APPLICATION TO MAKE A NON-MATERIAL CHANGE
TO THE FOLLOWING DEVELOPMENT CONSENT ORDER:
The A14 Cambridge to Huntingdon Improvement Scheme Development
Consent Order 2016 (SI 2016 No 547) (as corrected by the A14
Cambridge to Huntingdon Improvement Scheme Development Consent
(Correction) Order 2017 (SI 2017/1121))

6. Book of Plans

Drawing title **TRAFFIC REGULATION MEASURES REGULATION 5(2)(o) CLEARWAYS & WEIGHT LIMITS SHEET 2 OF 36**

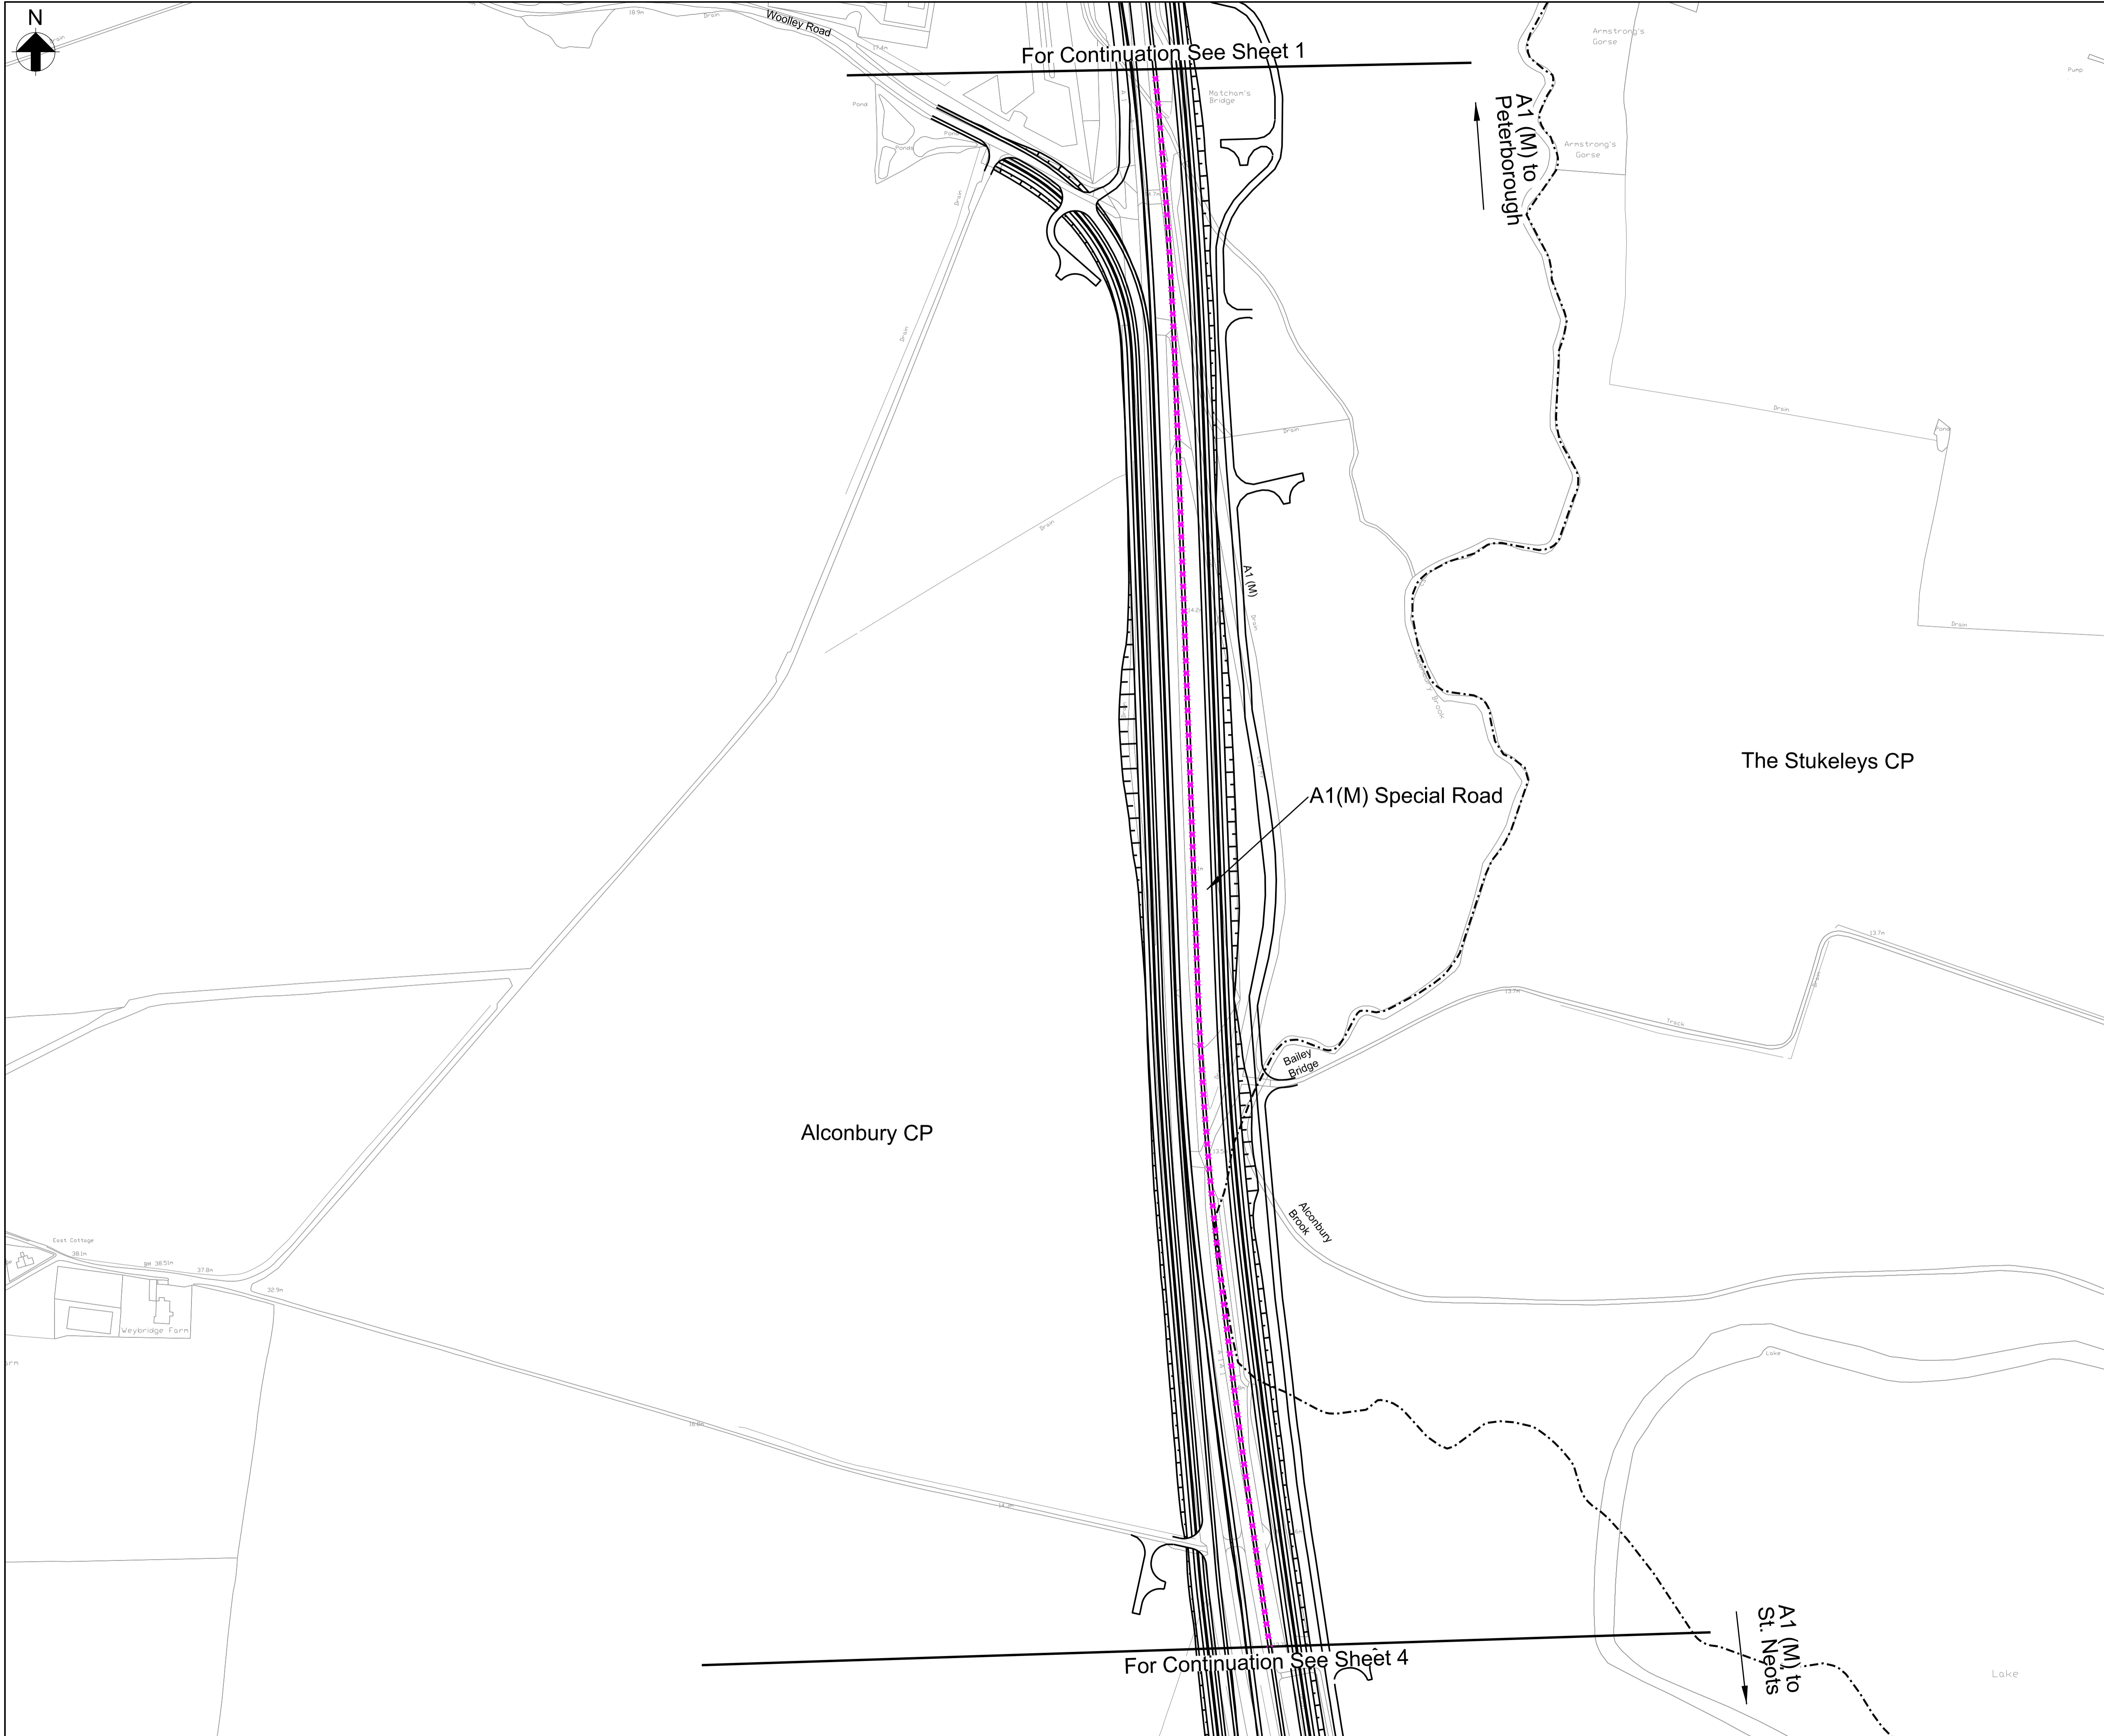
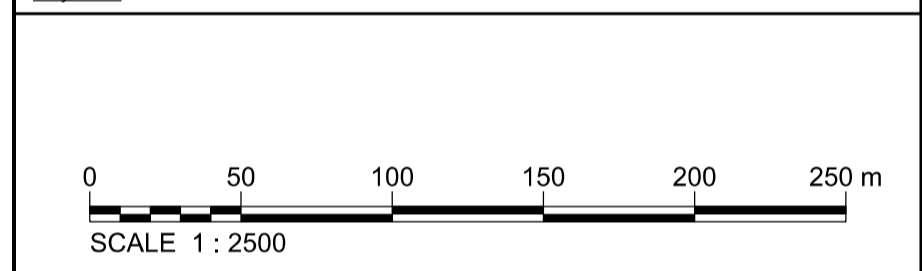
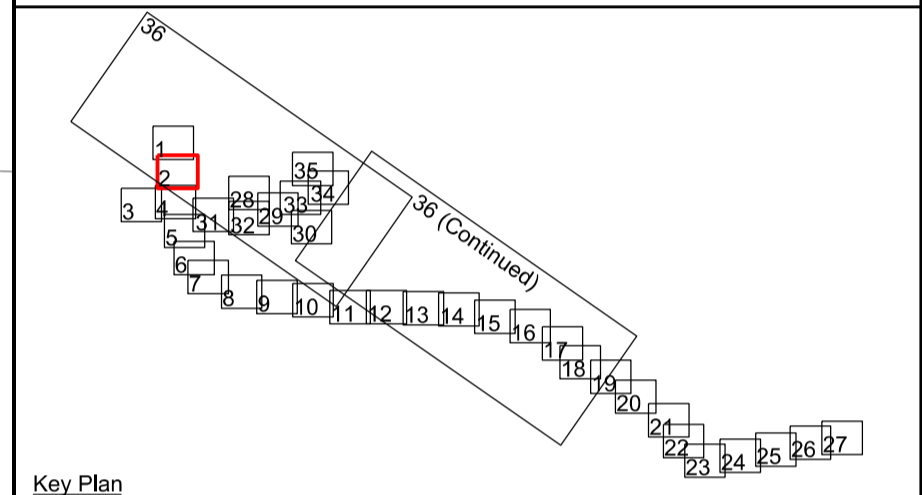
The removal of clearway on the mainline A14(M) and A1(M) as the Motorway Regulations include the provision of clearway.
